Chancel Cottage, Fir Lane, Steeple Aston, Bicester, OX25 4SF**Case Officer:** Ernest Addae-Bosompra**Recommendation:** Refuse**Applicant:** Mr Justin Grainger**Application Description:** Internal alterations, external alterations (including insertion of six rooflights), demolition of attached outbuildings and erection of single storey extension**Report Type: Delegated Decision****1. Site Description and Proposed Development**

Fig.29 - Proposed First Floor Plan

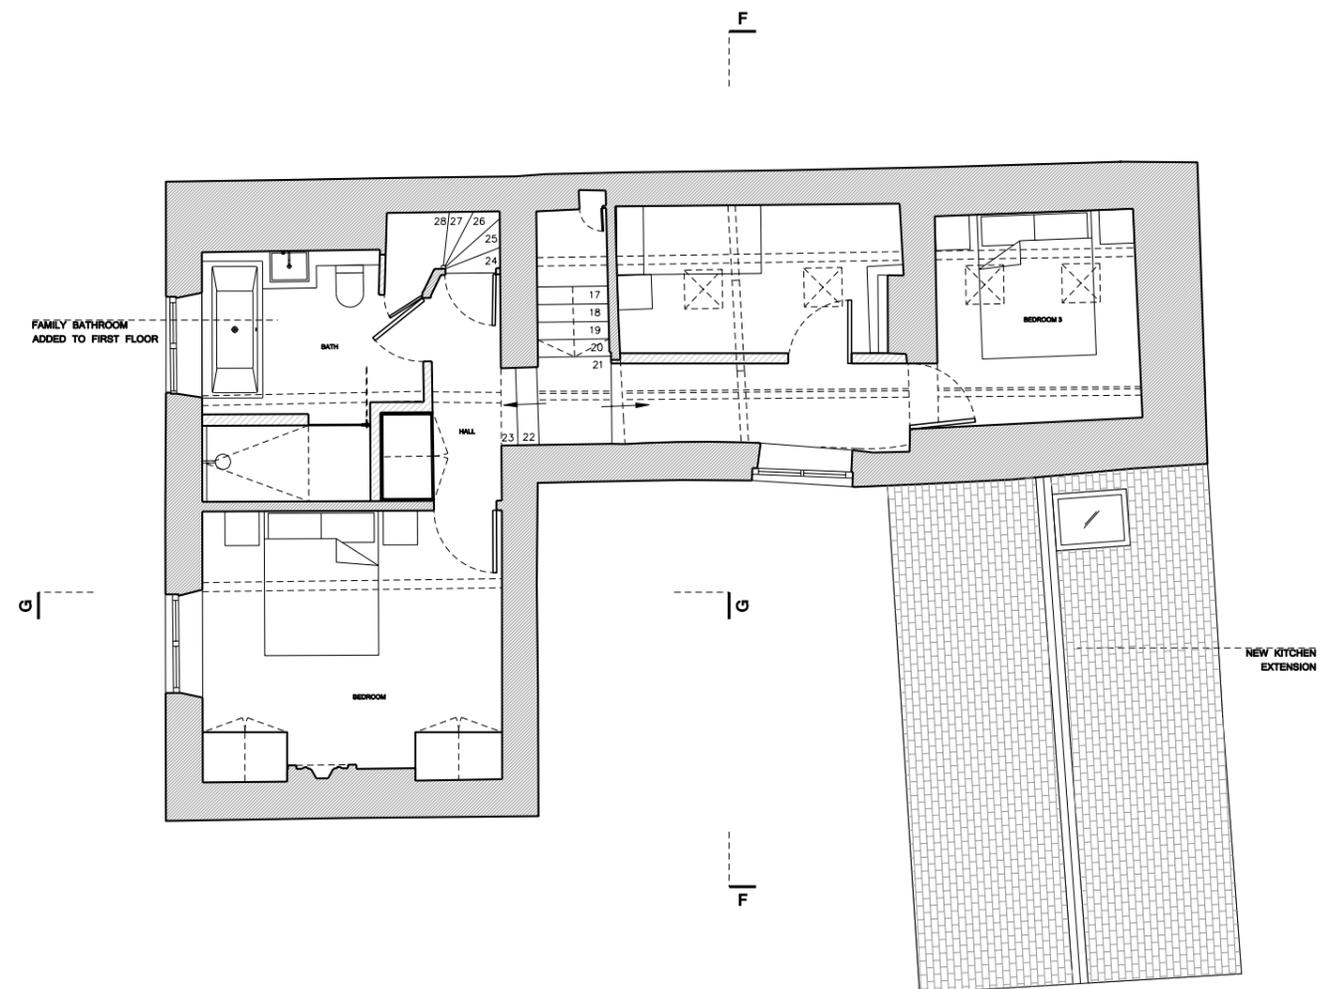
- 5.14 However, the proposal to form an additional doorway at first floor level is considered to have a more significant impact. The doorway is between the original stable range and the later 19th century addition, which was constructed as a physically separate structure. The ground floor area of the building has been brought into domestic usage, but the first floor area remains unconverted and unused. There is evidence of a former opening at first floor level which has since been blocked up. It is considered that there would be some harm to the significance of the site if this element of the building were to be converted, although this would need to be weighed against the public benefit of bringing this section of the building into use with the associated benefits of better maintenance.

- 5.16 Rooflights are not a characteristic element of simple, vernacular cottages such as this one and would have a detrimental impact on the character and appearance of the heritage asset. Although proposed to be set flush within the roof slope, the cumulative impact of the number of rooflights proposed is considered to cause substantial harm to the character and appearance of the listed building. The proposed use of the roof space for a further bedroom is considered acceptable in principle.

Chancel Cottage - Proposed West Elevation

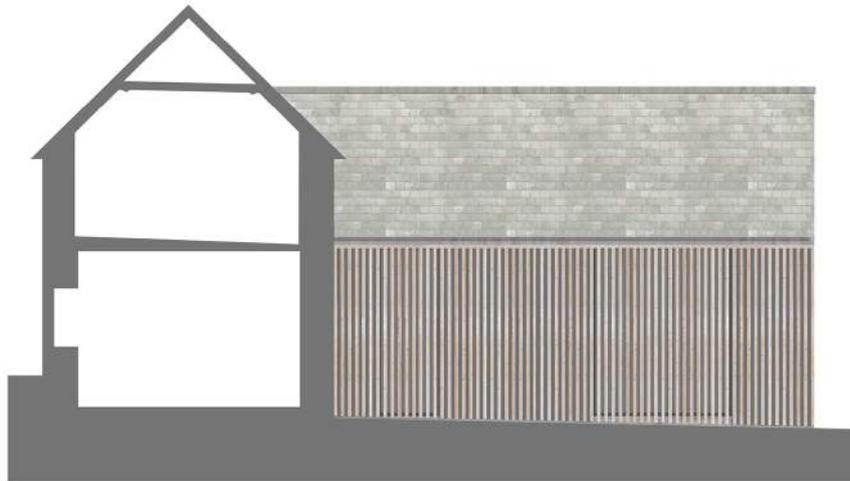
- 3.2 **Conservation Officer** – Objects, principally on the grounds that the form, scale and massing of the proposed extension causes harm to the significance / special interest of the listed building. Also concerned with the use of timber boarding and any dormers proposed (Detailed comments retained on file)

- 5.7 The extension is only marginally narrower (4.25m compared to 4.9m) and significantly longer than the original cottage (as noted above), thus fundamentally altering the experience of the building and creating a situation whereby the original cottage becomes subservient to its later extensions. The visual prominence of the extension verses the original building would be emphasised by the proposed use of timber slats/cladding to its walls. The fact that the extension is single storey is considered not to mitigate the harm caused to its fundamental form and massing.

- 5.19 However, the extension would be seen – both from the application site and from the churchyard to St Peter’s Church – in the context of the Church, which is Grade II* listed. The view of Chancel Cottage from the Church and its churchyard is currently one of the unaltered front elevation, with open, undeveloped space to the side, with views of the allotments and countryside beyond. Having regard to (i) the historic and cultural importance of the Church, (ii) the site’s location within the Conservation Area, and (iii) that the Grade II* listed Church is ‘surrounded’ by a cluster of approx. eight Grade II listed buildings, the intervisibility of the heritage assets and views from/to the heritage assets are considered particularly important.
